Planning application reference AW/181/15/HH

With reference to the above planning application, I wish to place formal objections to the proposed development on the following grounds:

north elevation onto Marquis Way

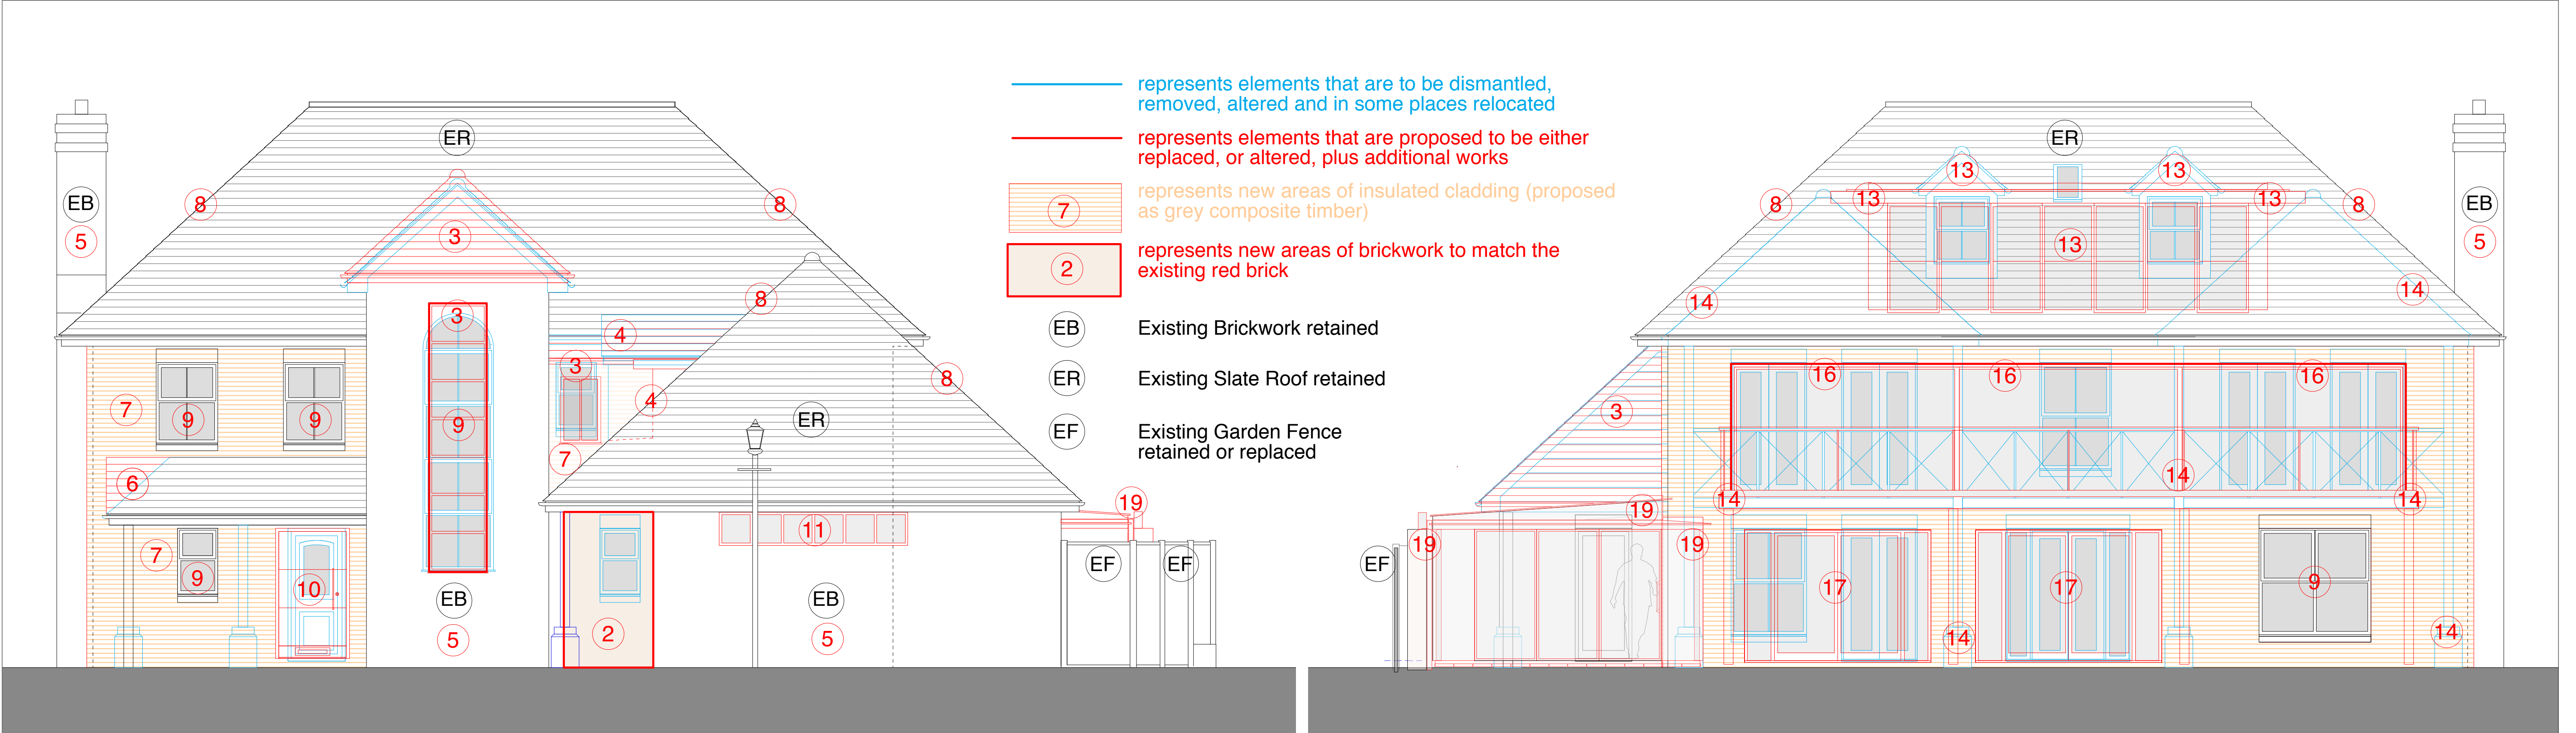
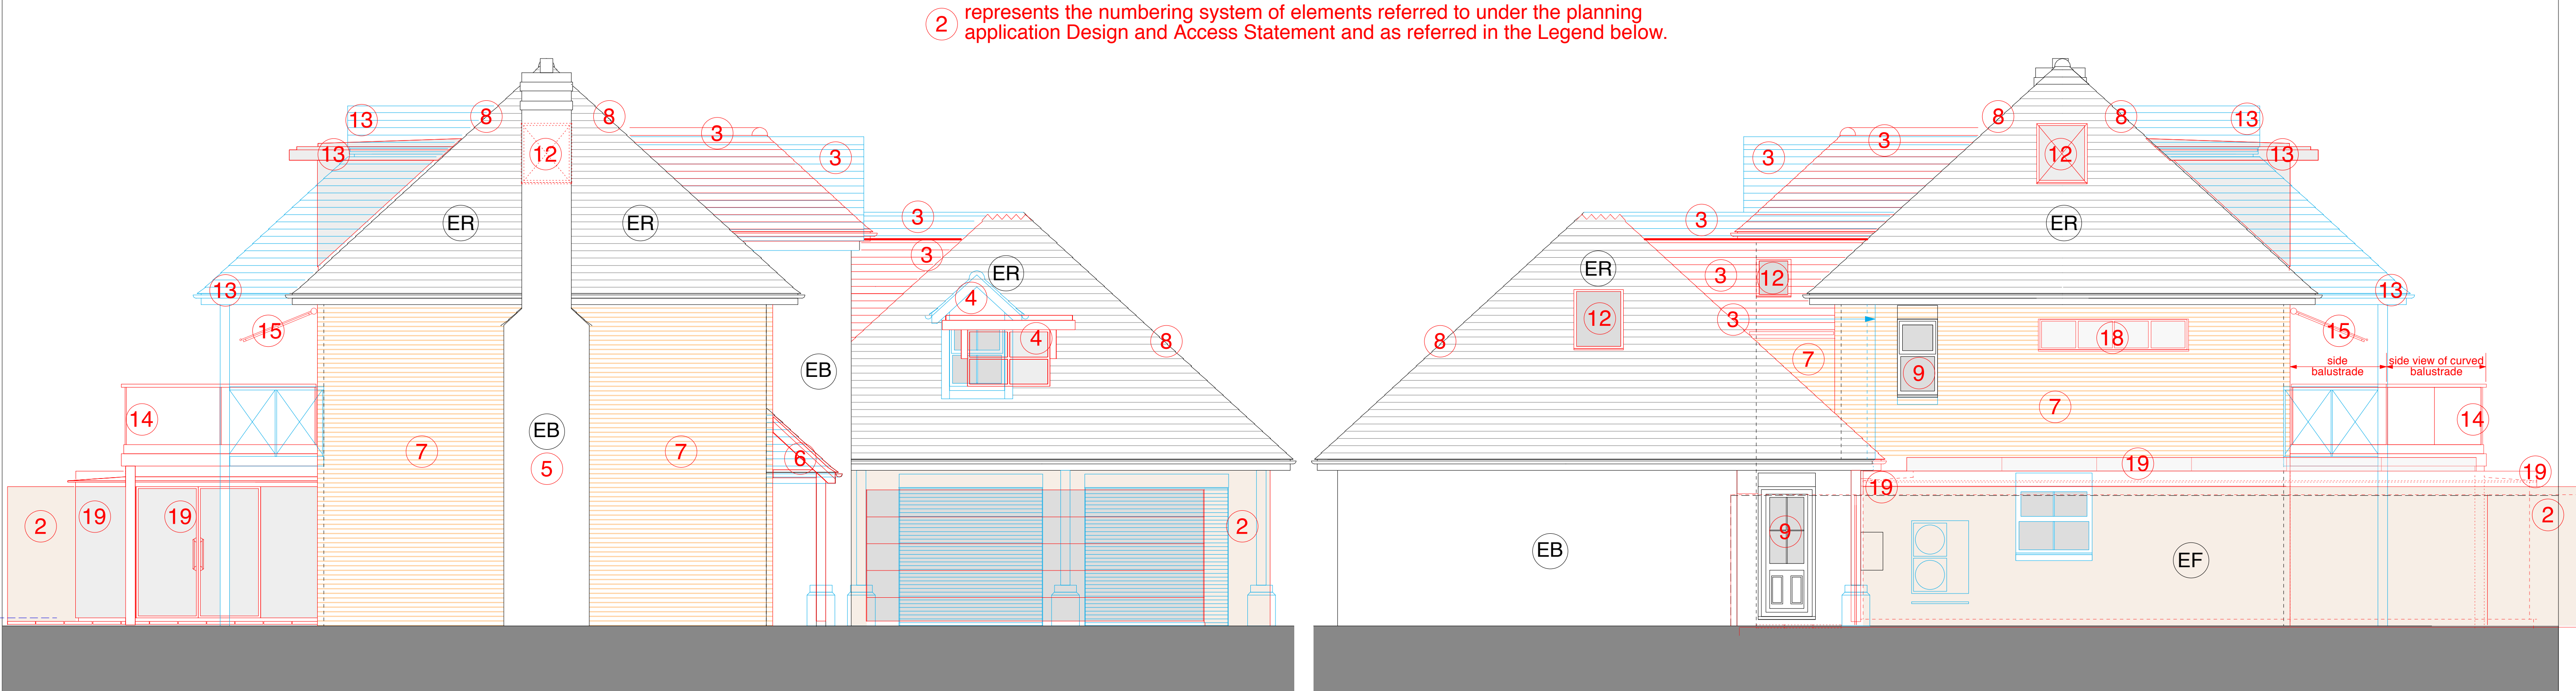
- 1 The proposed grey composite cladding would make the property completely different in appearance from any of the other twenty seven properties on the Marquis Way Estate. At least one previous planning consent¹ included the condition, *"The materials and finishes of the external walls and roof of the extension hereby permitted shall match in colour and texture those of the existing building."*

The external walls of this and all neighbouring properties are finished in either a light or dark coloured brick. The proposed form of cladding would alter the design and appearance (street scene) of the property in contravention of ADC planning policies **DEV19 (i) and (v)**, and would also be in breach of an existing Covenant².

- 2 The applicant proposes to replace the existing capping on the garage roof and house roof with lead flashing and mitred slate tiles respectively. This would also change the character and appearance of the property in relation to neighbouring properties and again contravenes ADC planning policies **DEV19 (i) and (v)**. It would also cause excessive dust and noise to the neighbours and wildlife on the beach, especially taking into account the strong winds across the property which will also increase the chance of materials blowing all over the beach.
